Application: SSI 7485

I write to **OBJECT** to all aspects of Modification 2 of the approved EIS Stage 3B Rozelle Interchange.

Figure 4-2 Pedestrian and cyclist bridge infrastructure options

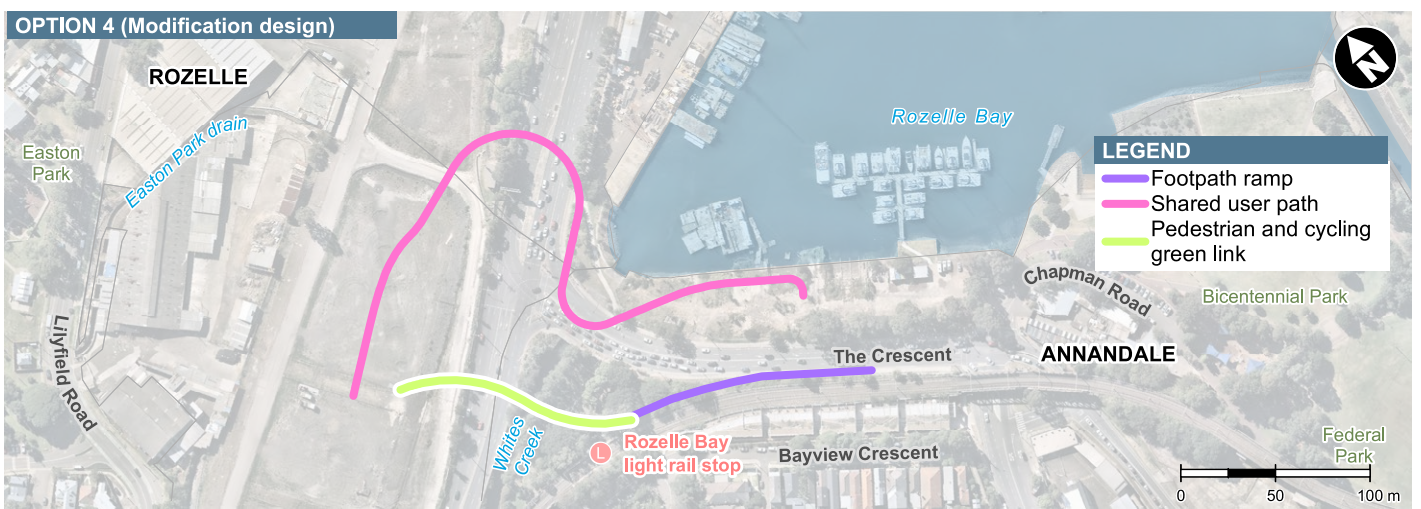
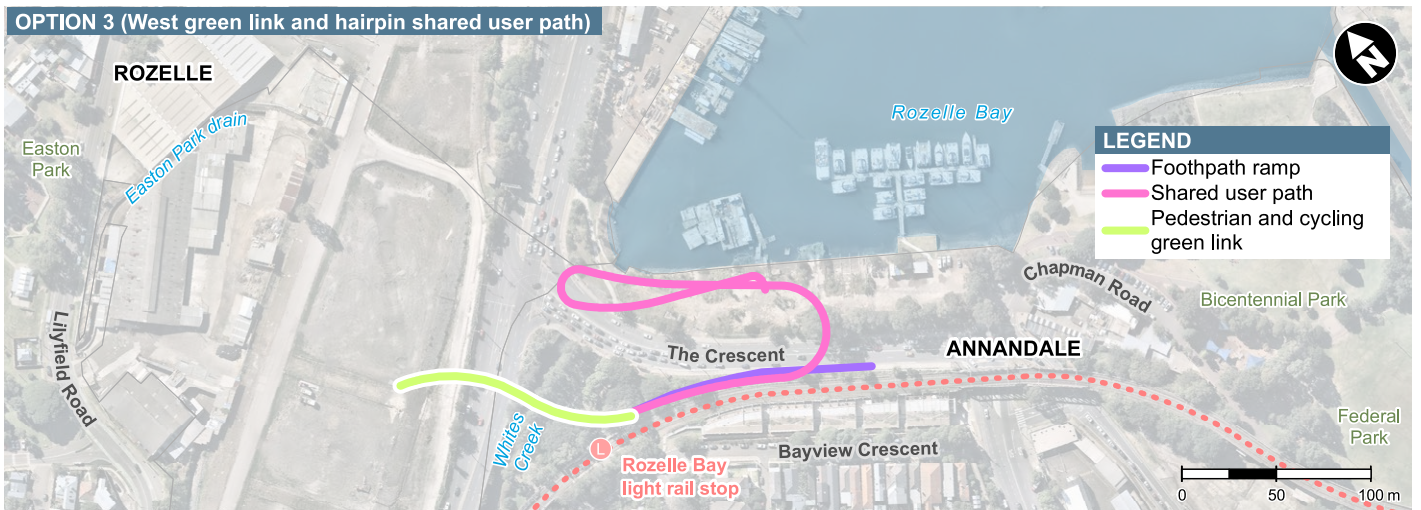
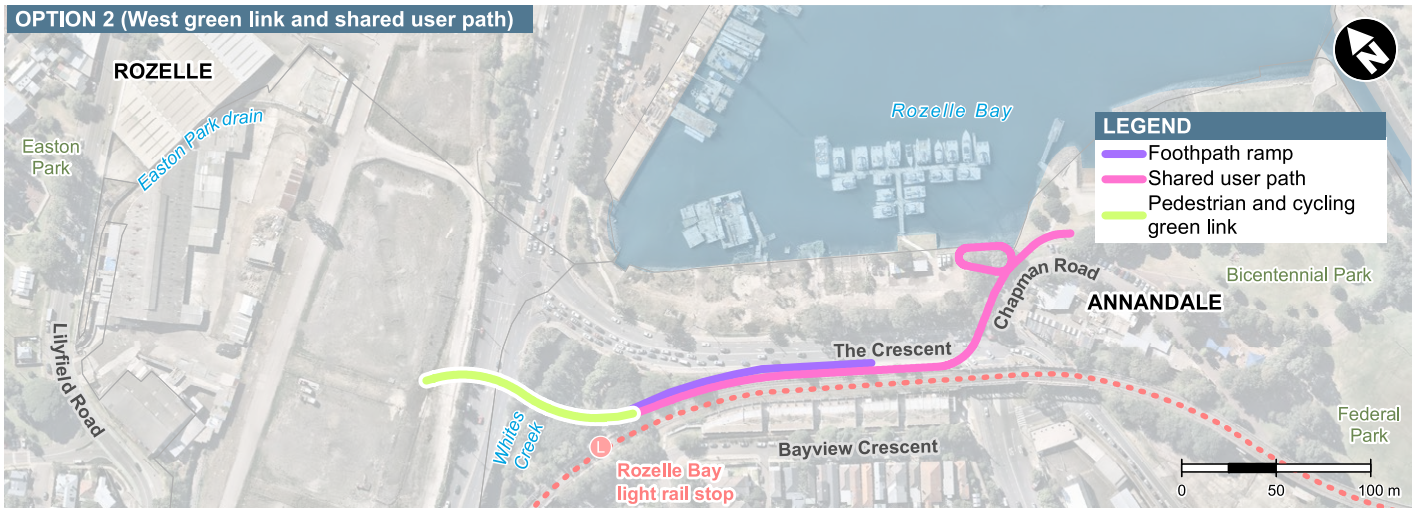
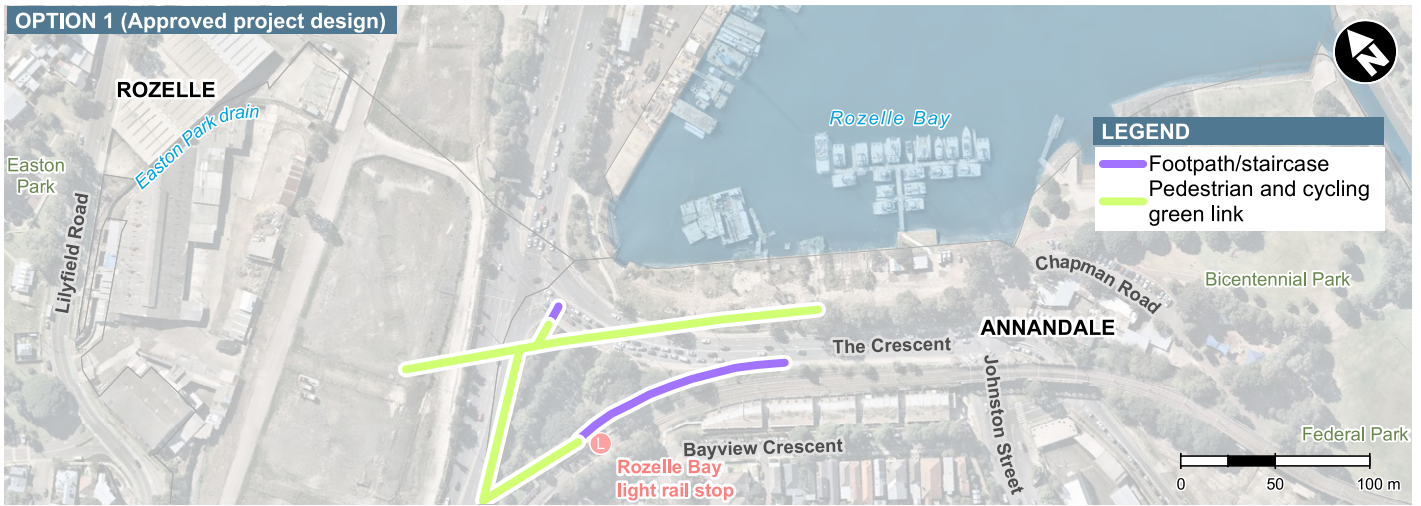
3. As compensation for the loss of the approved Greenlink, RMS proposes an Option 4 detailed in the Modification: **a 4.5m wide Shared User Path Bridge**. This fails on all levels:

- a. It does not provide a direct link to Bicentennial Park but drops you west of the park
  - b. It is twice as long as the current direct link which for the disabled, elderly and those with small children or prams, discriminates against them.

- c. It is certainly not wide enough creating a 1.1 metre single file path for both north and south travelling pedestrians and cyclists.

- **Option 2**, which is detailed in the Modification AND as originally published by the RMS in its August 2018 Western Harbour Tunnel brochure, should be adopted which maintains the commitment made by the NSW Government to provide a wide, safe and direct active transport link from the Rozelle Goods Yard to Bicentennial Park. The arguments raised by RMS that option 4 is safer for users than option 2, is illogical and self serving to justify option 4. Both options have the same issues – being stuck out over the City West Link wont help someone any more than walking along option 2. Option 4 must also be a far more expensive build (not that any figures were provided to review in the Modification) compared to Option 2.

Figure 4-4 Elevation: Indicative view of The Crescent overpass

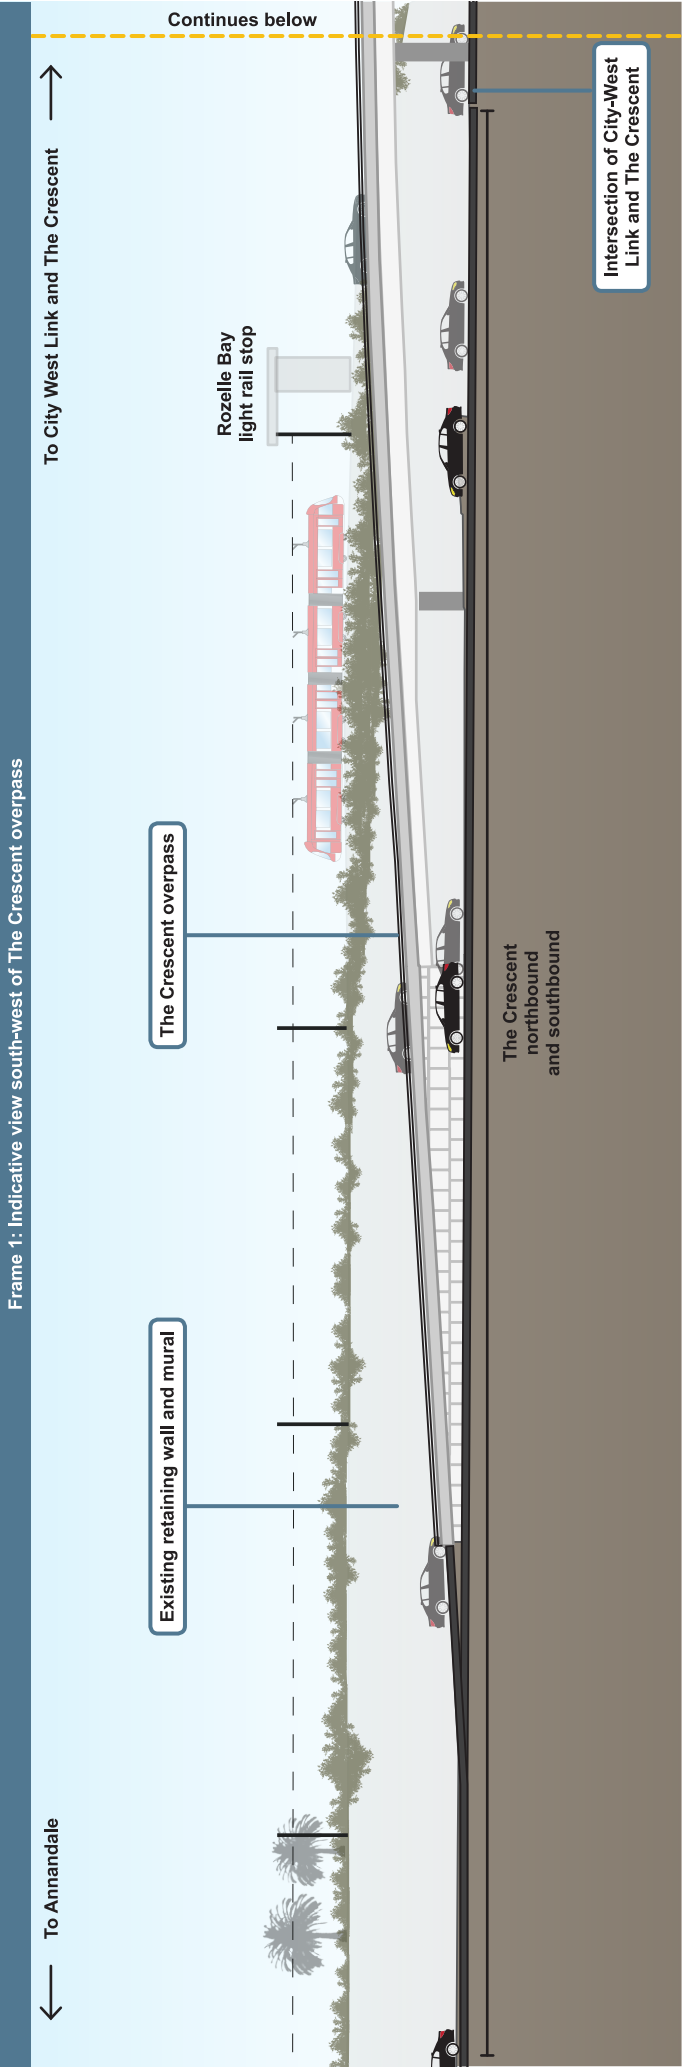
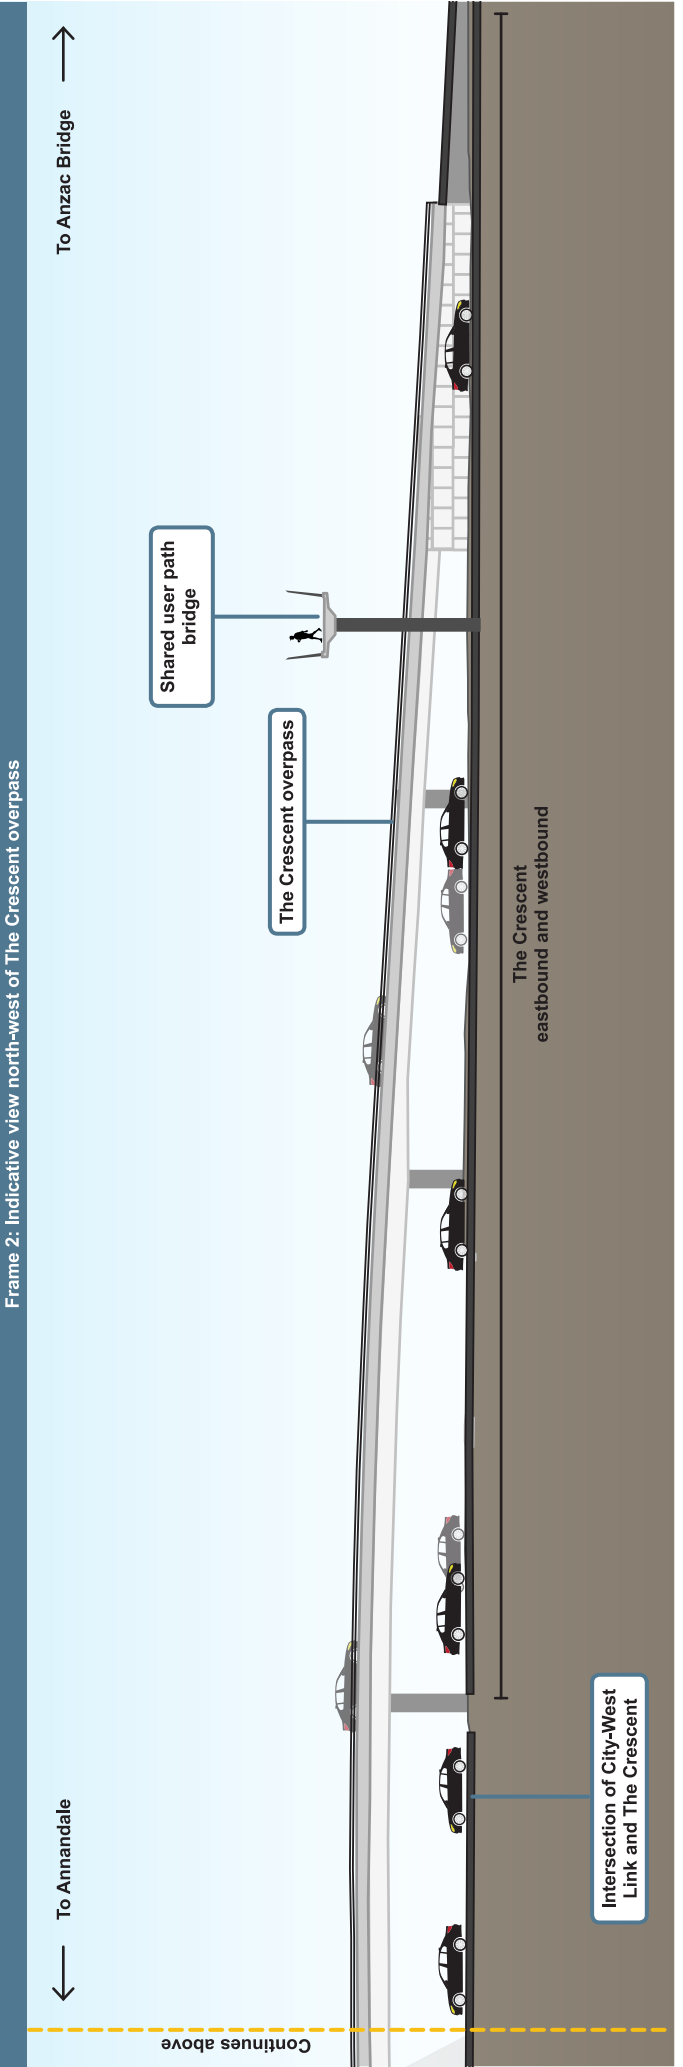
1. A **2 lane Overpass is inconsistent with the rest of the project** which was to minimise its impact on the surrounding community and environment. By having the proposed Overpass above ground, it adversely impacts the aspects and amenity of residential homes in Annandale, Rozelle and Lilyfield and the users of both Bicentennial Park, in Glebe and Easton Park, Rozelle. Increased noise and light spill from the overpass will adversely impact residents. The Overpass also destroys the integrity of the Heritage Crescent Mural.

- Landscaping solutions must be found to shield every resident and park user from the visual, light and noise impacts created by the Overpass.
- Traffic solutions must be found to all negative traffic impacts created by this Modification.

Figure 4-6 Elevation: Indicative view of Rozelle Rail Yards Pedestrian and Cycling Green Link

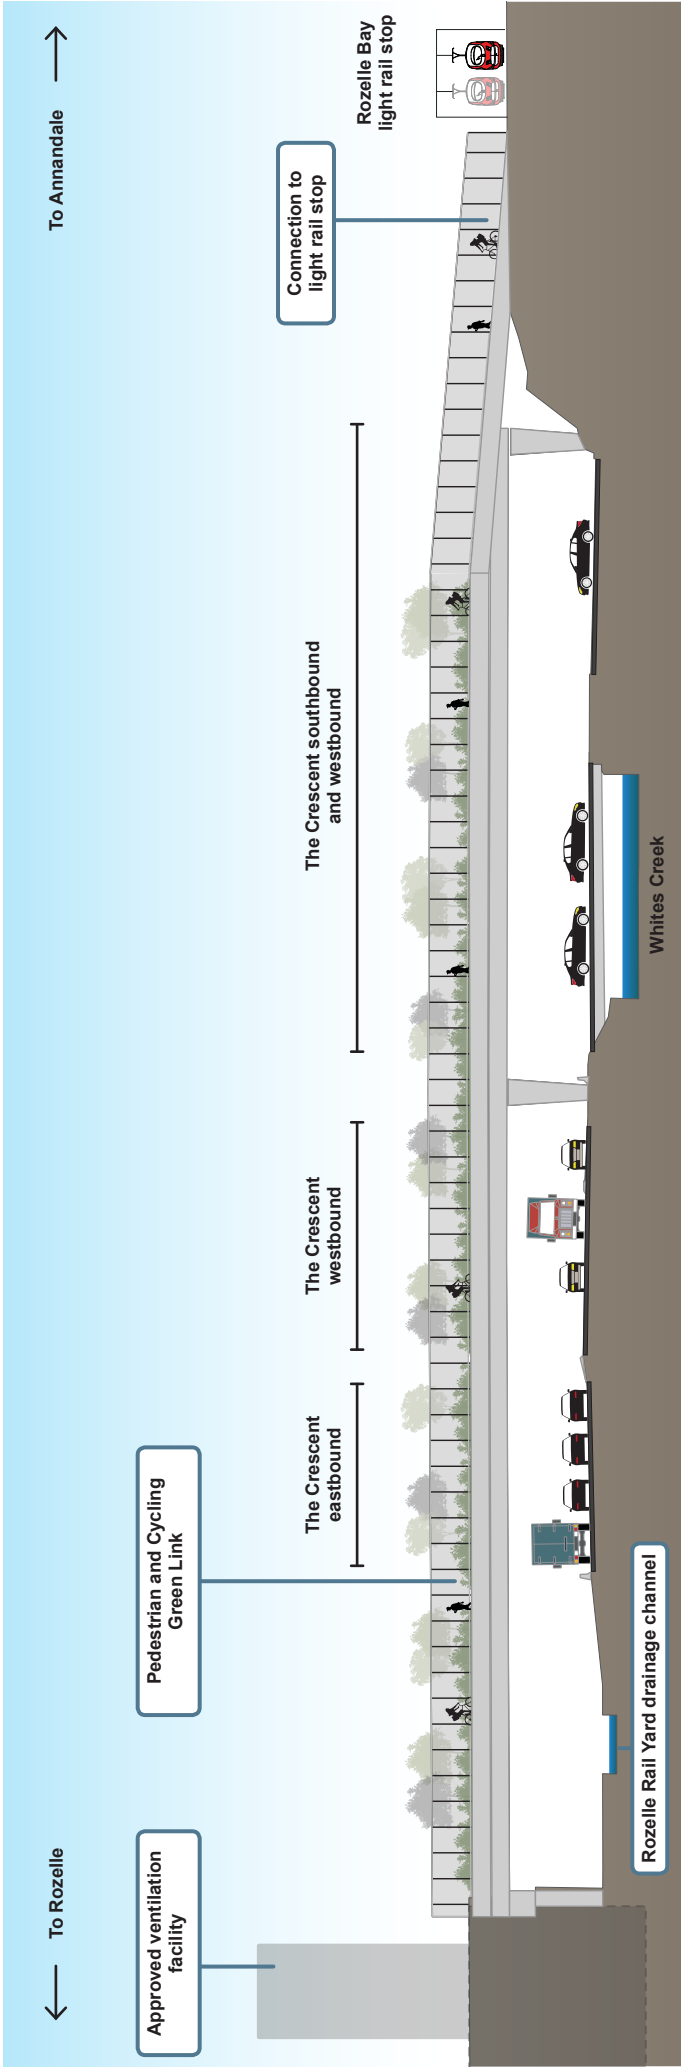
2. The **integrity of the approved Greenlink** to create a shared transport link from Rozelle Rail Yards to Bicentennial Park will be decimated. The Greenlink will now be halved, linking The Rozelle Rail Yards only to the Rozelle Bay light rail station. Pedestrians and cyclists will then need to negotiate a narrow path to road level and then interact with traffic via 4 sets of lights to access Bicentennial Park instead of the current 1 pedestrian crossing. What madness is this? Putting people and traffic back on the same interactive plane!
